Mark E. Jones, PE
Structural Engineering and Design

Ref: Site Observations and Analysis
4165 Mcdougald Rd.
Lillington, NC
Project No. 21-143

FOUNDATION PLAN
 1/4" = 1'-0"

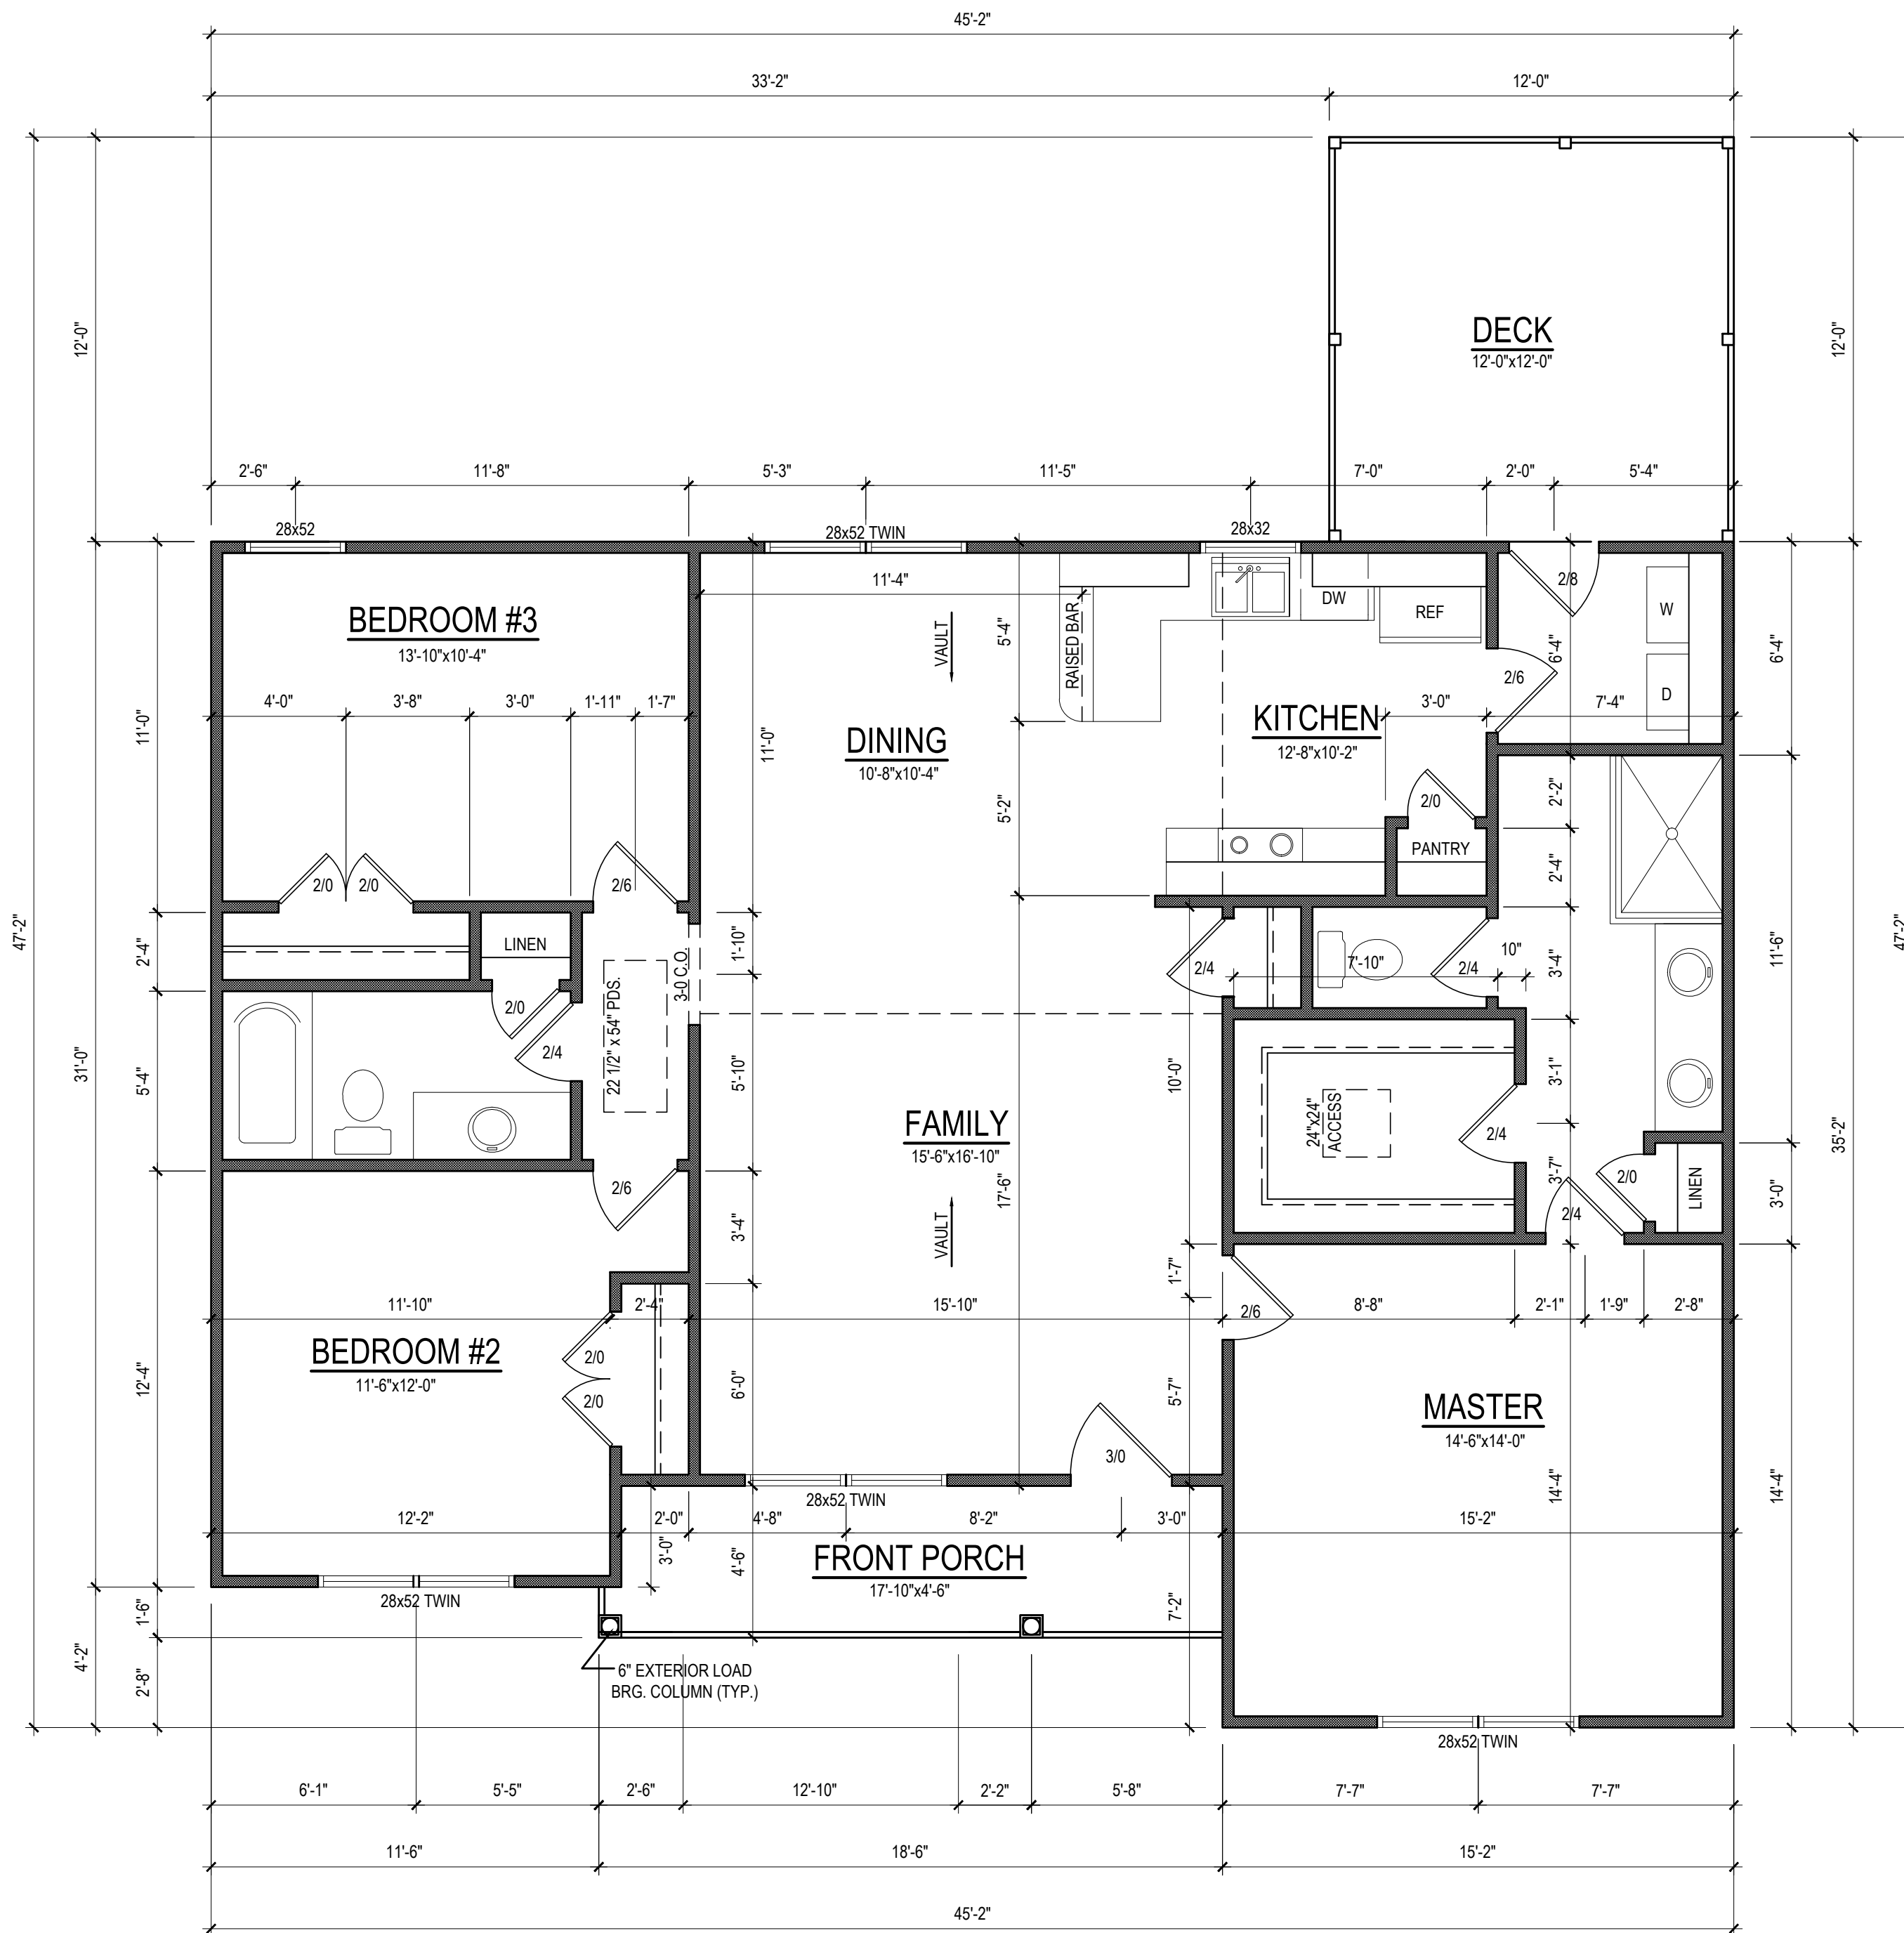
1. Front right flush pier needs to be in the center 1/3 of the footing.

1. The footing for the referenced pier was over excavated resulting in the pier being constructed off center on the footing. Upon inspection it was observed that the pier had been constructed 12" off towards the rear. The builder has rebuilt the pier in the proper location and resulting in the pier being in the center third of the footing. No further repair is required.
